Permit Number: 071396

November 19, 2007

RE: 836 Washington Avenue (Unit 8) – 170 B017008 - R-5 – build an 8' x 20' deck –  
Permit #071396.

Drawing file: Building Permit / 041202 site.pdf

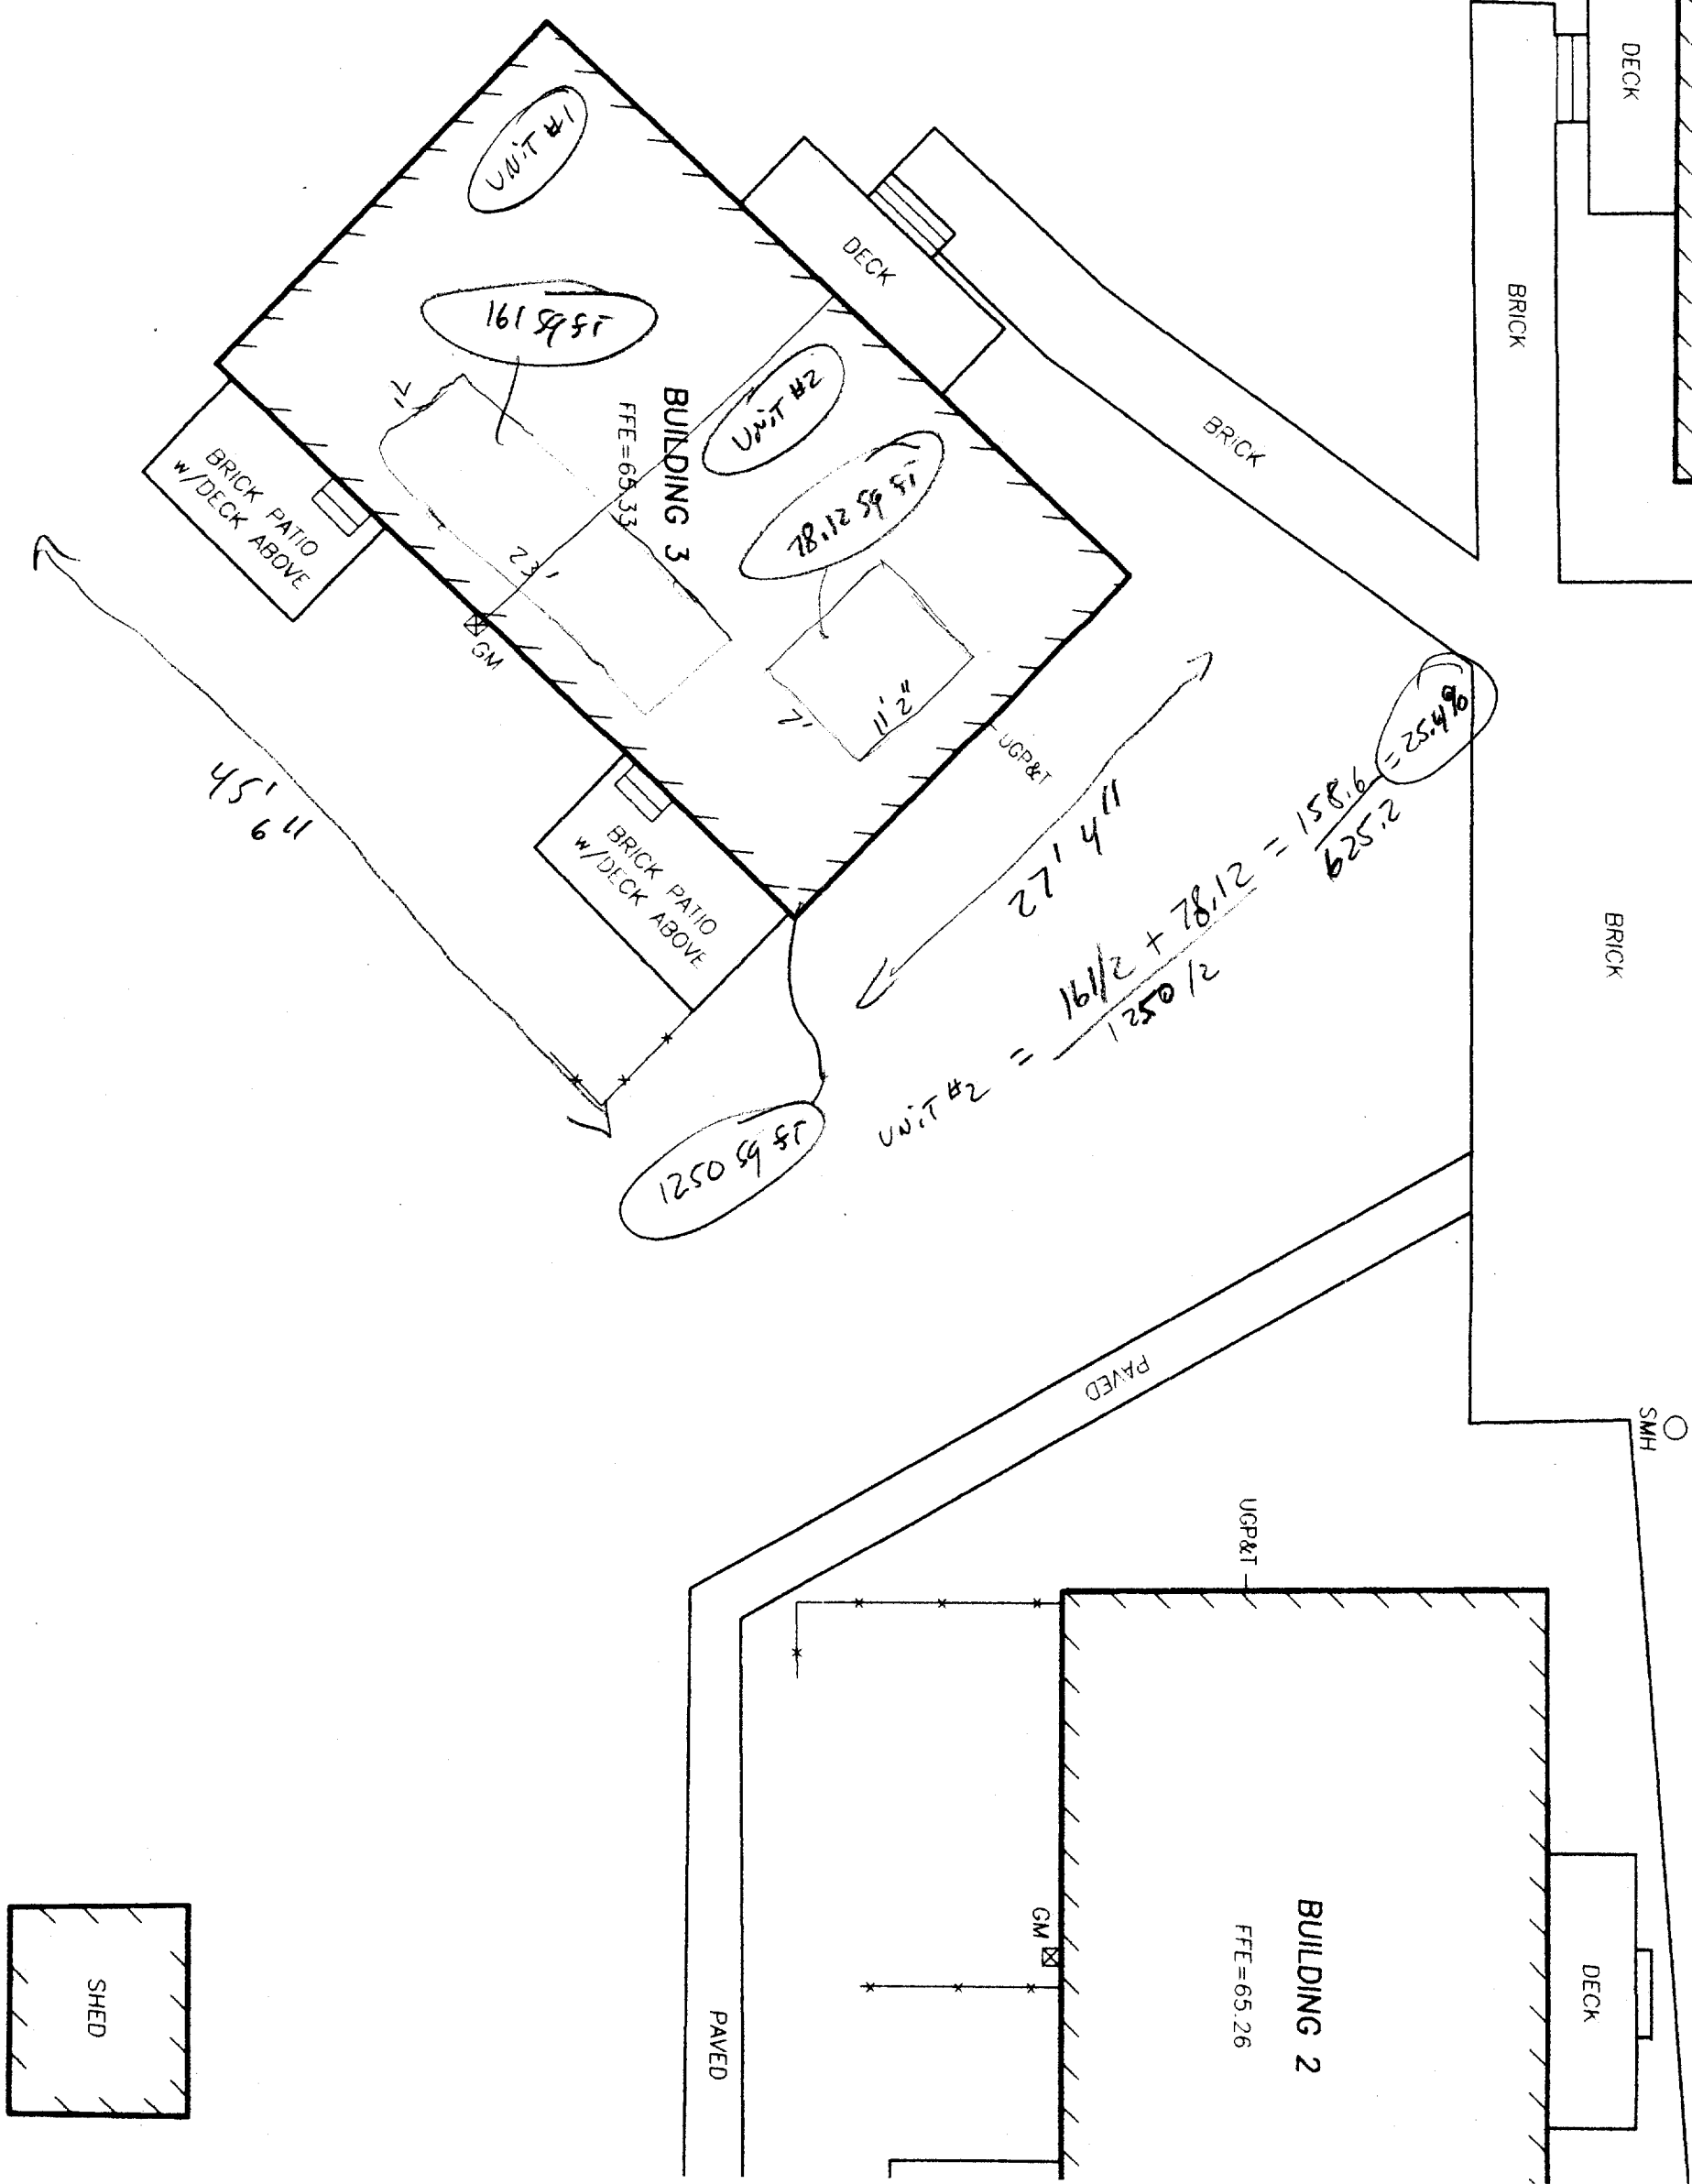
I have reviewed your application to build a twenty foot by eight foot deck at your condominium at 836 Washington Avenue (Unit 8), and I must deny it for two reasons. The first reason is that your condominium does not meet the minimum land area per dwelling unit requirement in the R-5 residential zone. The minimum land area per dwelling unit for a property with three or more residential units is 6,000 square feet per dwelling unit (section 14-117(2)(a)). There are twelve residential units on the property, and the size of the lot is 46,624 square feet. To meet the land area per dwelling unit requirement, the lot would need to be 72,000 square feet, so the lot is legally nonconforming. The ordinance, under section 14-388, states that a building that is nonconforming as to area per dwelling unit cannot be enlarged unless the building can be made to conform to the land area per dwelling unit requirement. Since the lot is legally nonconforming as to land area per dwelling unit, you cannot enlarge the existing building, so your permit is denied. Also, the minimum side yard setback in the R-5 residential zone is eight feet for a one story structure (section 14-120(d)(3)). The setback provided on the plan is seven feet, so the proposed deck does not meet the side setback requirement and must be denied.
